Your Ref: OWPC22307
Our Ref: FG/6/19/PL 14-01-2019
Please ask for:
Andrew Wood

New dwelling
20 Rife Way Ferring

Thank you for your internet representation made on 23rd April 2019 which has been recorded as '**an objection**' with the comments as follows:

Drawing No.
Drawing 5
Proposed West
Elevation

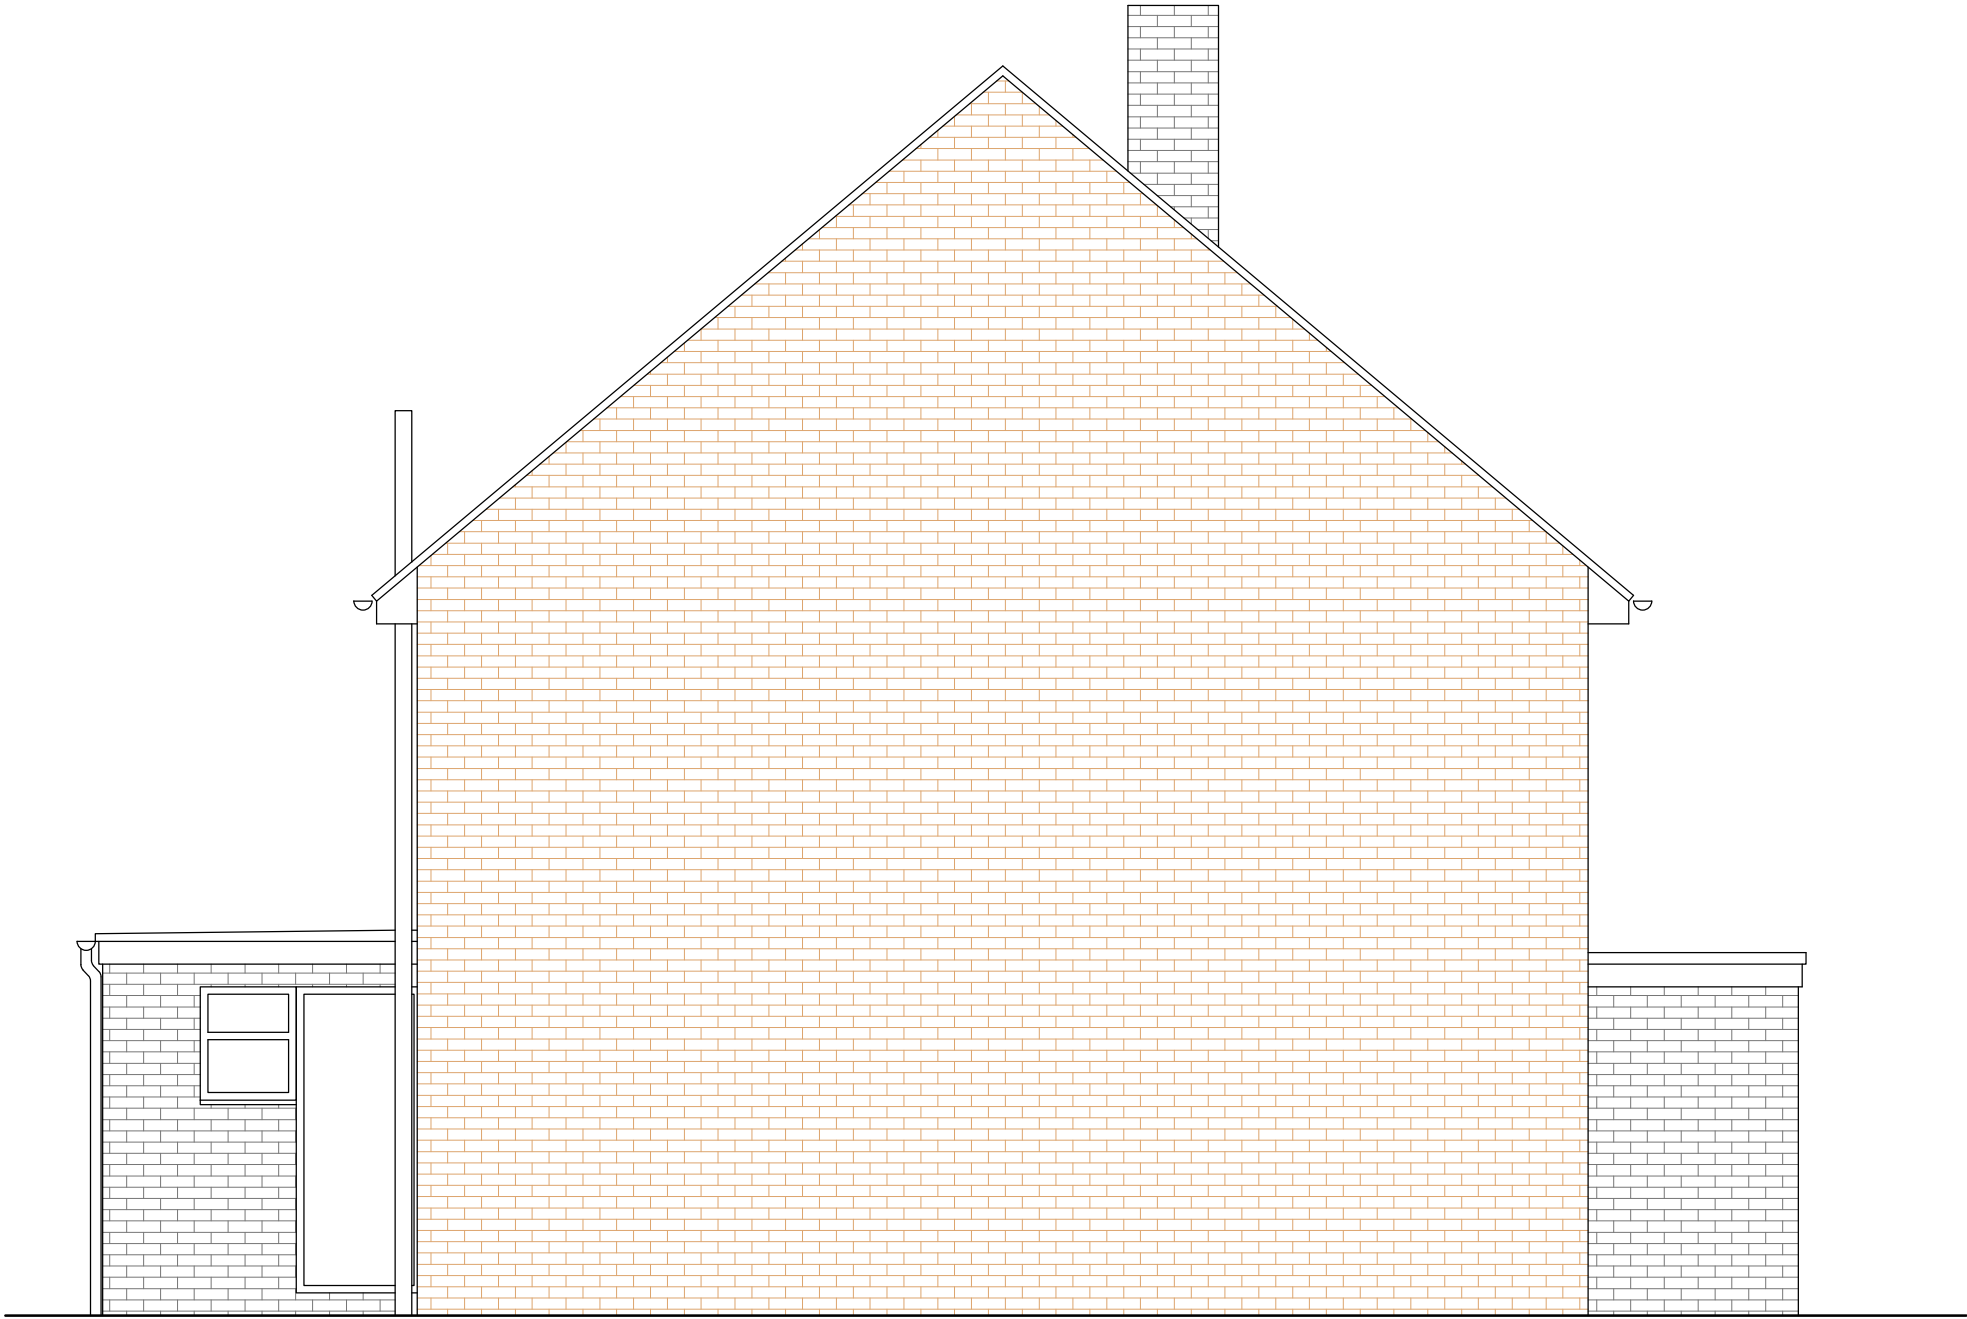
I object to this application in that it seeks to cram another property into a small garden site with little or no aesthetic value. In fact the western elevation is a large plain brick wall fronting right on to St Maurs Road at the end of what would be a terrace.
